Project Name:	SSD 25725029 – Ardex Warehouse and Manufacturing Facility
Reference:	21.1137.FL2V1
Status:	Final

Further to your email dated 22 December 2021 and associated comments received on the Air Quality Impact Assessment (AQIA) for the proposed Ardex Warehouse and Manufacturing Facility located at Kemps Creek, prepared by Northstar (21.1137.FR1V3, 5 November 2021), please find overleaf our response to relevant Department and Agency comments relating to air quality. It is noted that comments have also been received from Penrith City Council, although no comments requiring a response in relation to air quality were received.

Figure 7 Receptors including in dispersion modelling

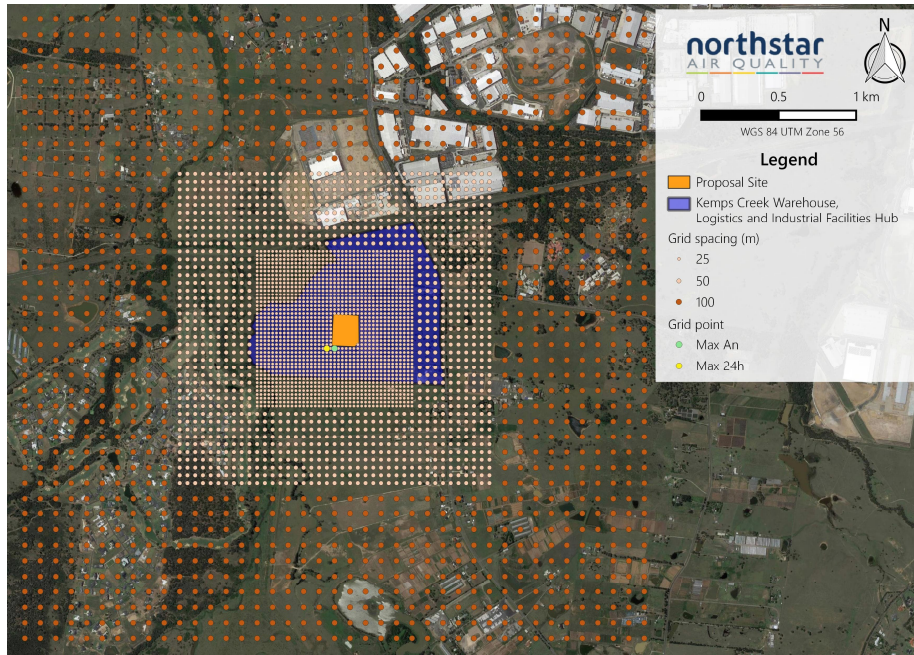
Department / Agency	Comment	Response
Department of Planning, Industry and Environment (DPIE)	24. The Department requires the AQIA to be revised to include a map identifying the sensitive receptors used in the assessment. Details of the property addresses are also required.	Figure 7 provided in the AQIA (ref 21.1137.FR1V3) provides a uniform grid map of the modelled receptors. As the exact location of sensitive receptors at off-site locations was unknown at the time of the assessment, a conservative approach has been adopted which provides predicted impacts at off-site locations on a uniform grid. For the purpose of the assessment, all of the individual receptor points shown on Figure 7 were considered as 'sensitive receptors' within the assessment. As the exact locations of these are unknown, no property addresses are available.
